Tom Greer
Pinkham and Greer, Civil Engineers
28 Vannah Ave
Portland, ME 04103

**RE: St. Lawrence Arts Addition (Contech Reference No. 541,937)
Review of Filterra Design**

FILTERRA 6x4 OFFLINE STANDARD
LONG SIDE INLET
MODEL: FT0604

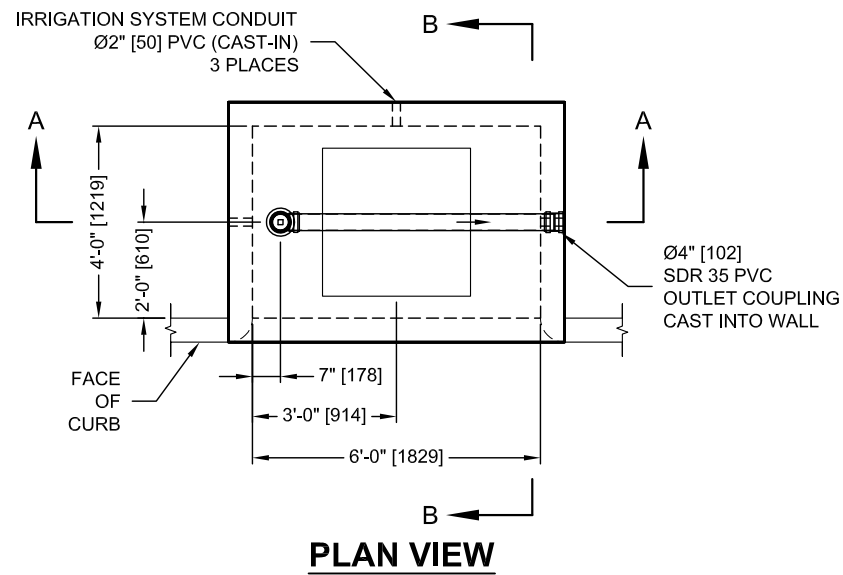
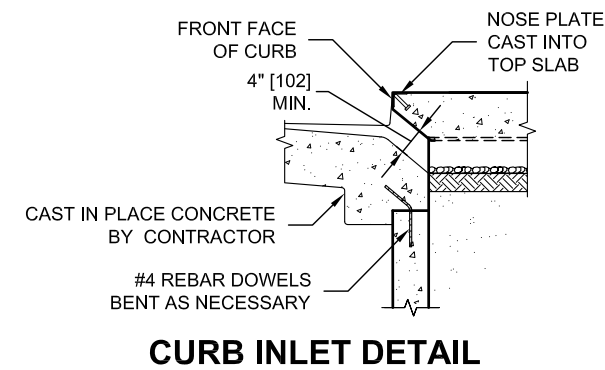
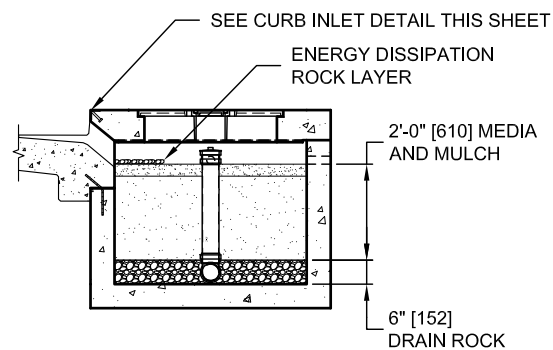
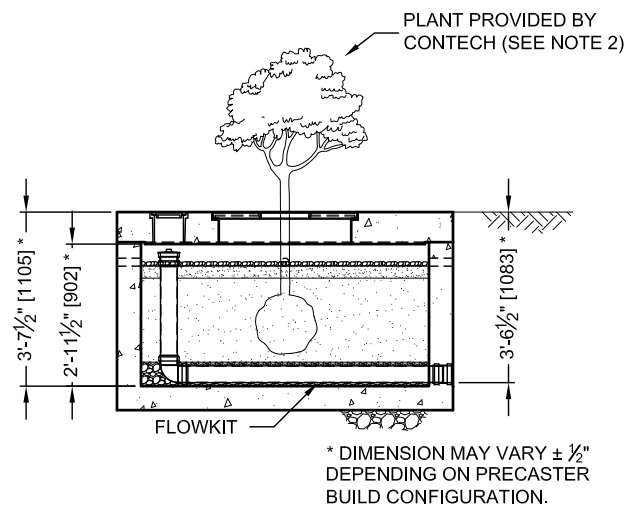
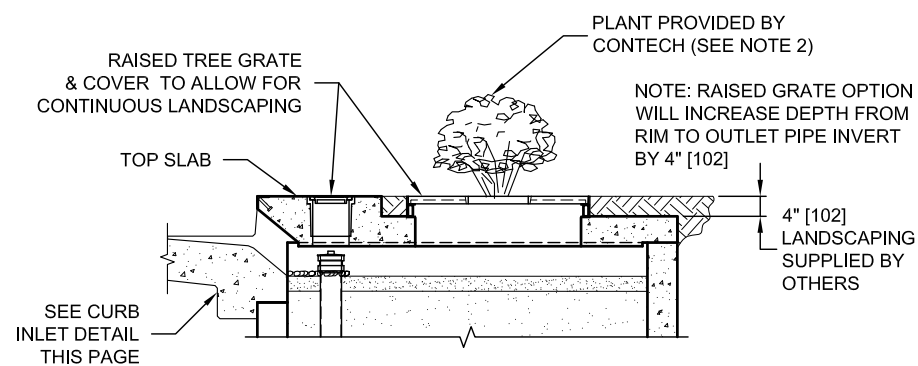
The engineer of record reports a totally impervious drainage area of 0.138 acres. The Filterra was designed in accordance with the sizing design guidelines to treat 90% of the annual runoff volume prior to bypass. In order to adequately treat the runoff from this area, Contech recommends a 6'x4' Filterra.

The configuration of the Filterra is acceptable. The system appears to be constructible and is located in order to facilitate maintenance activities. Our systems require periodic maintenance to continue operating properly. Given typical runoff pollutant loading rates, Contech recommends maintenance inspections on an annual basis. Based on the location of the system, we anticipate replacement of the mulch layer every 12 months for the system to continue to remove pollutants. Contech will be responsible for the first year of maintenance as included in the purchase of the Filterra unit; subsequent years of maintenance shall be performed by a third party at the owner's expense.
